From: Laura Gibbons
Sent: 18 January 2019 09:30
To: Planning.Responses
Cc: Michael Eastham
Subject: RE: Planning Consultation on BE/2/19/DOC

Engineers Comments Regarding Condition 9- Surface Water Drainage

Registered: 08-JAN-19
Site Address: Land At Salt Box West Of Shripney Road Bognor Regis PO22
 9NW

Description of Approval of details reserved by condition imposed under ref
Works: BE/102/17/OUT relating to Condition No 9 works. BE/102/17
 Conditions(s) 9 surface water drainage and Condition No 10
 foul drainage.

Drawing Title: PHASE 1 DRAINAGE STRATEGY PLANNING SHET 2 OF 3

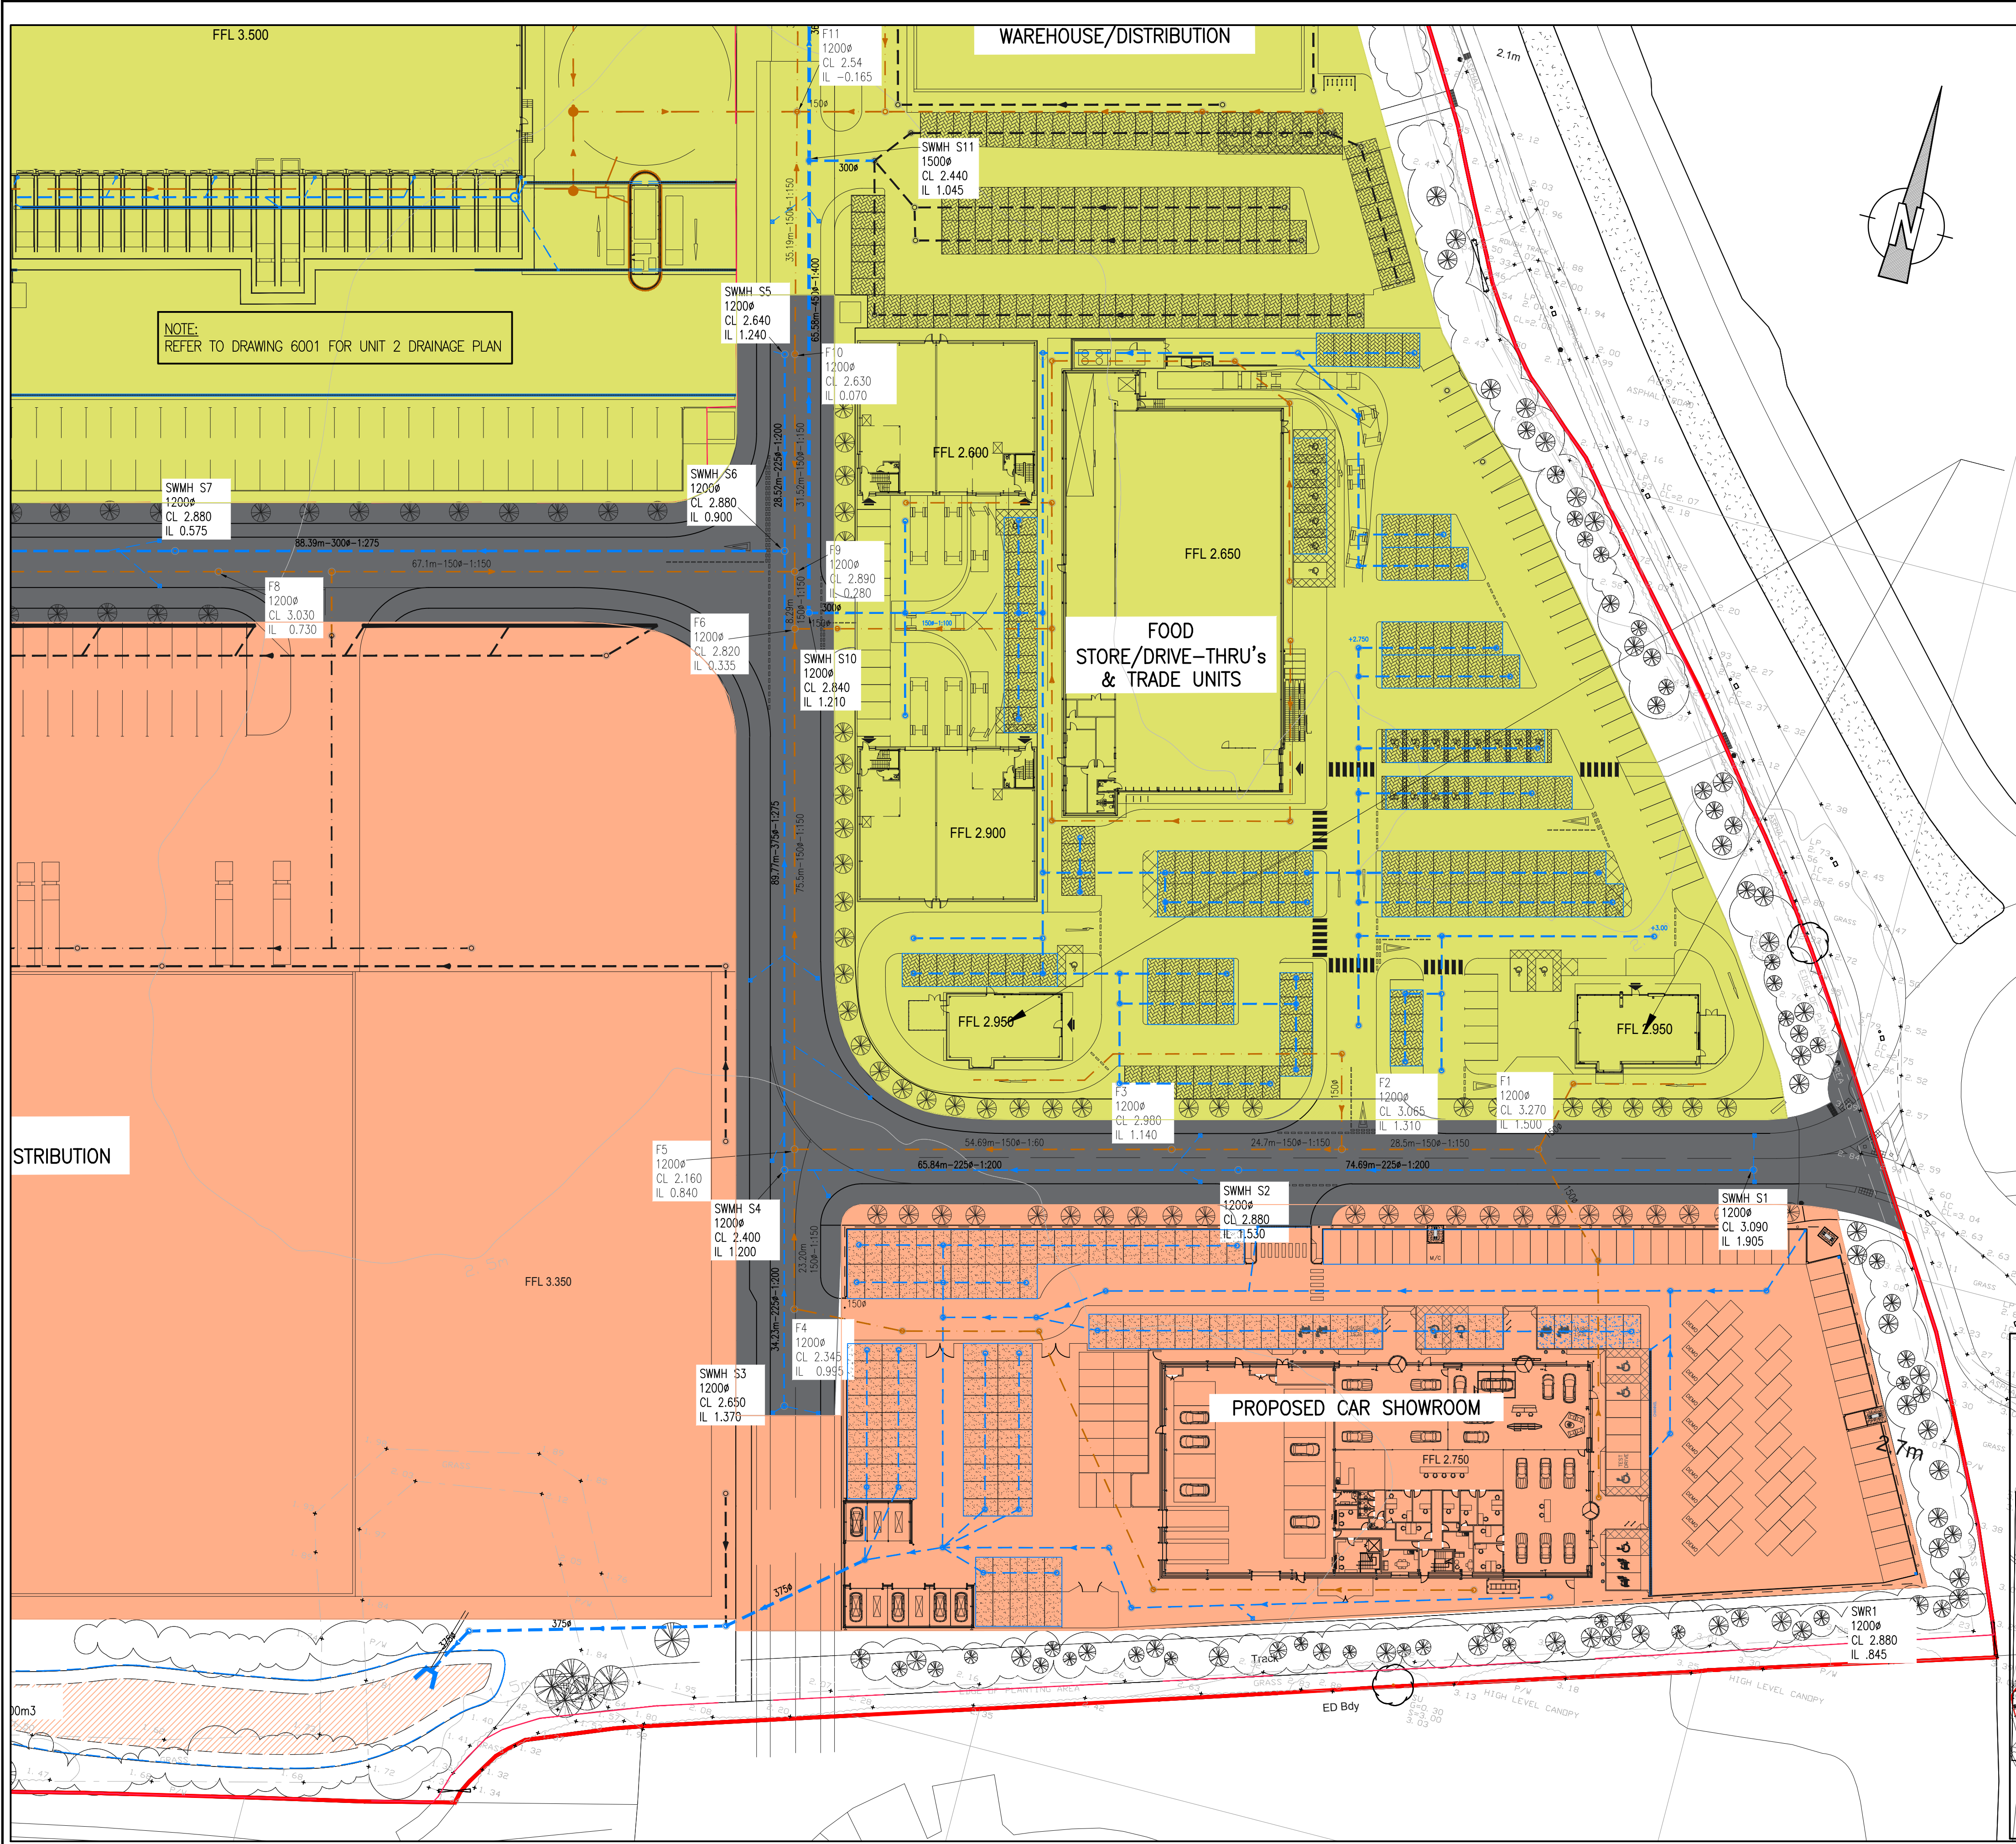
- As stated in the condition we require the submission of winter groundwater monitoring results and winter infiltration test results.
- Calculations must be provided to evidence that the development will not increase flood risk and that the 1 in 100 year plus 30% climate change allowance.

- If discharge to main river is required evidence of the predevelopment sites QBar will need to be provided.
- Details of how sufficient treatment is being achieved within the SuDS

- Full detailed construction level drawings need to be provided of the surface water drainage layout and construction details of each of these elements.

- Information regarding maintenance requirements needs to be submitted to demonstrate that the drainage is adequate now and in the future.
- Furthermore, the proposals are to discharge to a main river, without an Environmental Permit for Flood Risk Activities being provided it is not possible to determine if the proposed scheme is appropriate.
